Preliminary Acceptance Punchlist
El Paso County – Department of Public Works - Stormwater Section

Project Name:	Struthers Ranch Polaris
EDARP Filing Number(s):	PPR2248, CON2319
ESQCP Number:	ESQ2315
Attendees:	DPW SW: Shannon Mustoe, Benjamin Jones DPW Development Services: Spencer Pirzadeh Developer: Contractor was present (Todd Jeffers and one other)
Date of Walk-through:	06/17/2024
Walk-through Number:	1 st

Water Quality Pond A (Sheet C3.1):

WATER QUALITY POND A  
PLAN & DETAILS

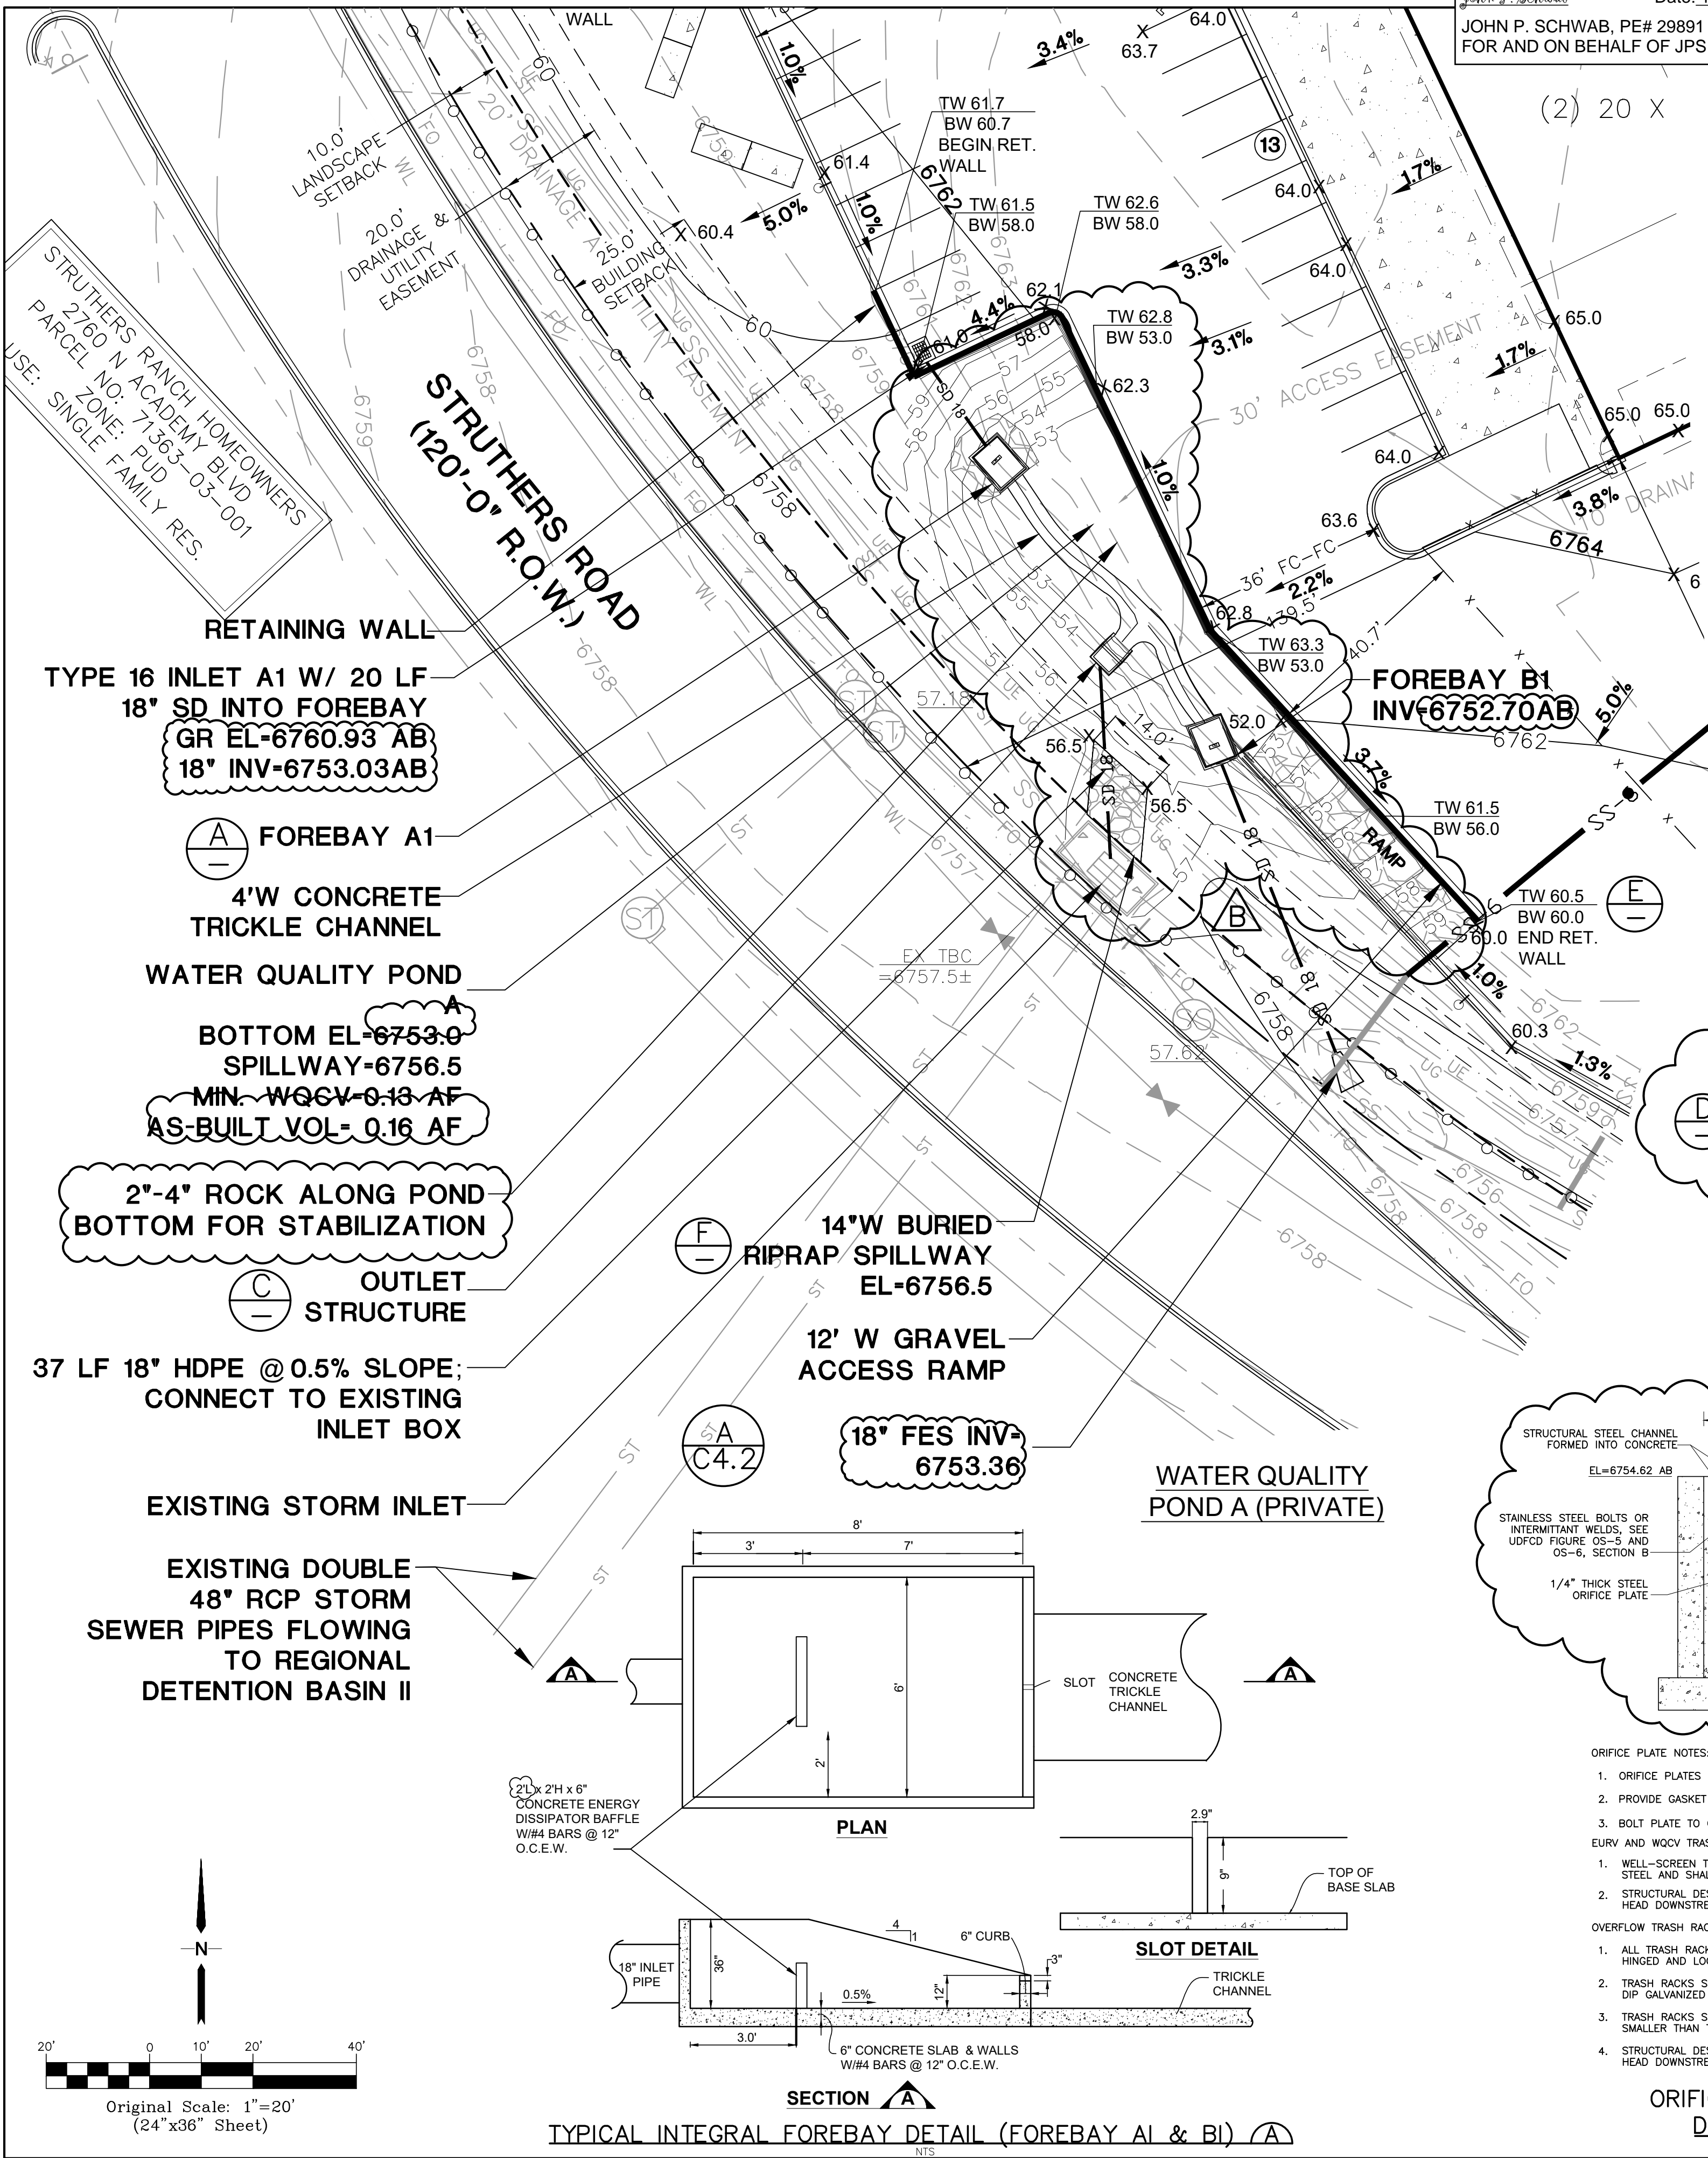
- Add lock/hinge at top of safety grate.
- Access Ramp/Maintenance Access Road:
 - Plans call for Class 5 or 6 road base. 2-4" stone was installed. Show on as-builts. Reference Photo 4.

TYPICAL CONCRETE  
TRICKLE CHANNEL (B)  
NOT TO SCALE

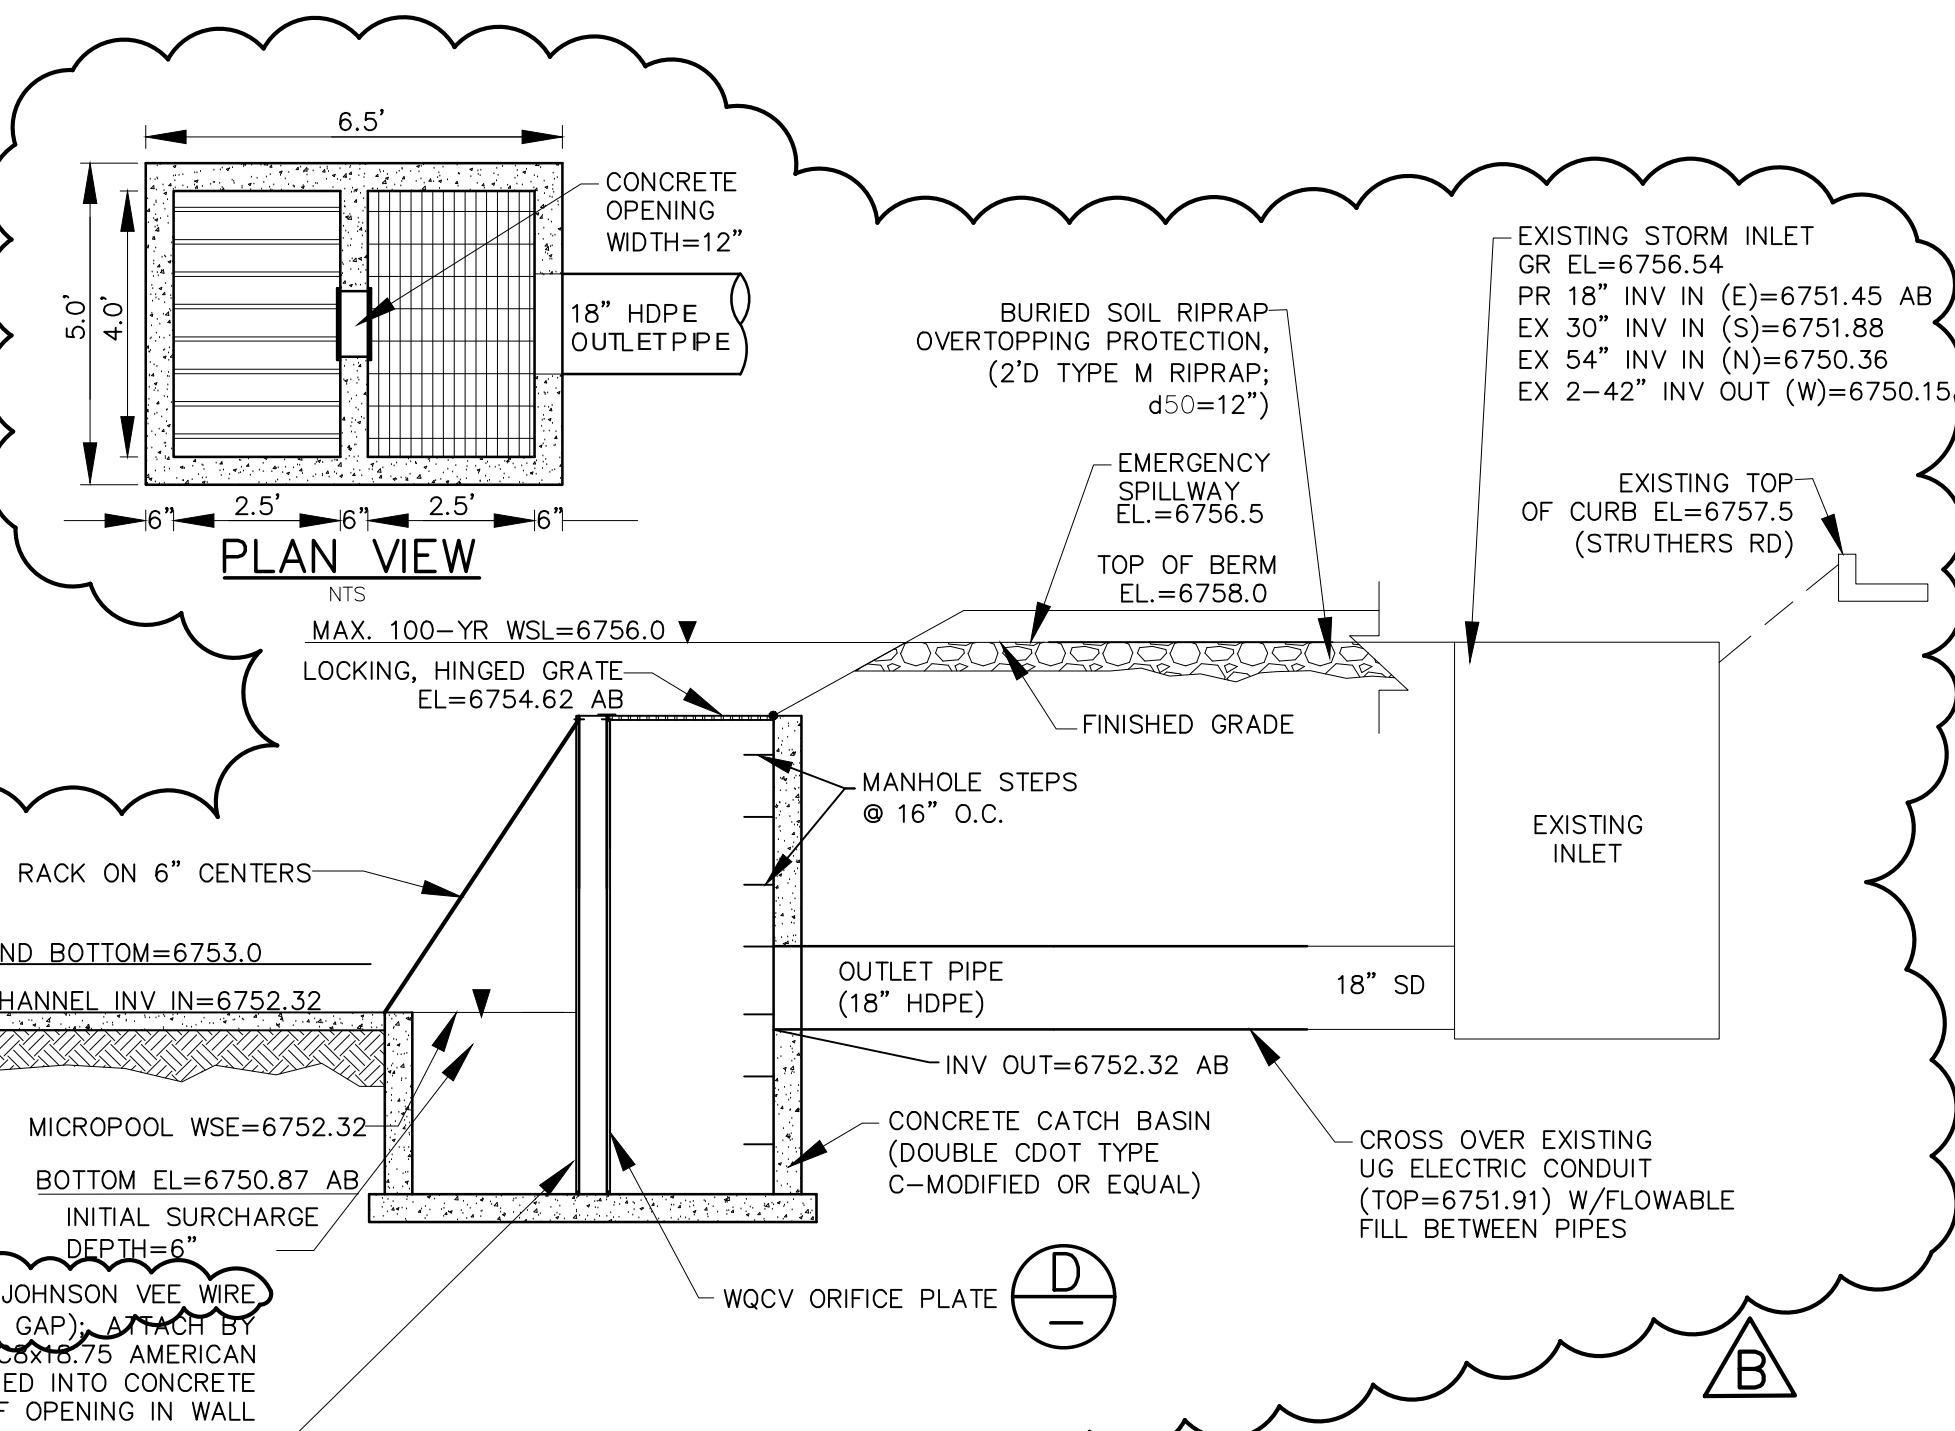
- Trickle Channel: Appears to be about 1” in depth. Plans call for 6”. Install per approved plans or confirm with your project engineer that this change from the plans is acceptable and then reflect the change on the as-builts. Reference Photo 3.

- Pond Bottom
 - Pond bottom below grade of trickle channel curb. Fill to match top of trickle channel. Reference Photo 3.
- An approved "PCM Maintenance Agreement" (formerly the "Private Detention Basin / Stormwater Quality Best Management Practice Maintenance Agreement and Easement") has not yet been signed by the responsible party and uploaded to EDARP. Please work with EPC Stormwater Staff to resolve.

SECTION  
TYPICAL DETENTION POND OUTLET STRUCTURE (C)  
SCALE: NTS

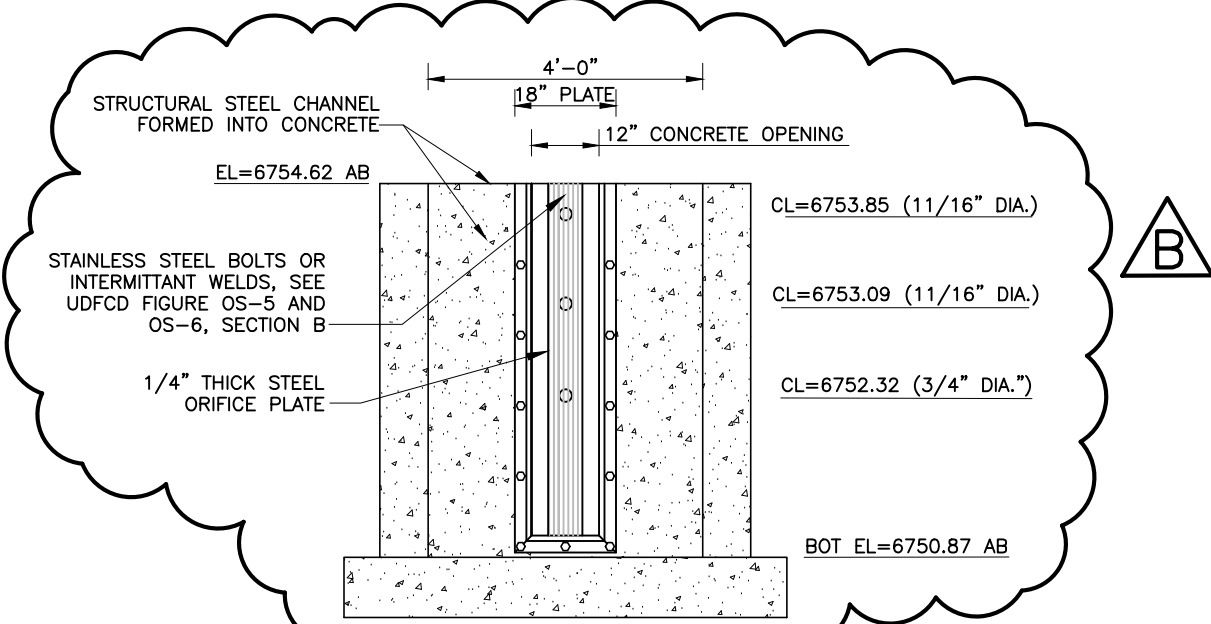
- Outlet Structure:
 - Outfall structure is 3’9” tall, as opposed to 6’ on the plans. Install per approved plans or confirm with your project engineer that this change from the plans is acceptable and then reflect the change on the as-builts. Reference Photo 6.

- Orifice plate: Cannot see bottom two holes. Assess elevations. As mentioned above, the entire structure appears to be smaller than what is on the approved plans. Distance from outfall pipe invert to trash rack is 2.2’. Plans call for 3.5’.

- 12” Concrete opening width is covered with Johnson Vee Wire with ½” gap. Show on as-builts. Reference Photo 5.

- Vertical Trash Screen: Plans call for Amico-Klemp Bar screen. Johnson Vee Wire is installed. Show on as-builts.
- Install trash rack above micro pool.
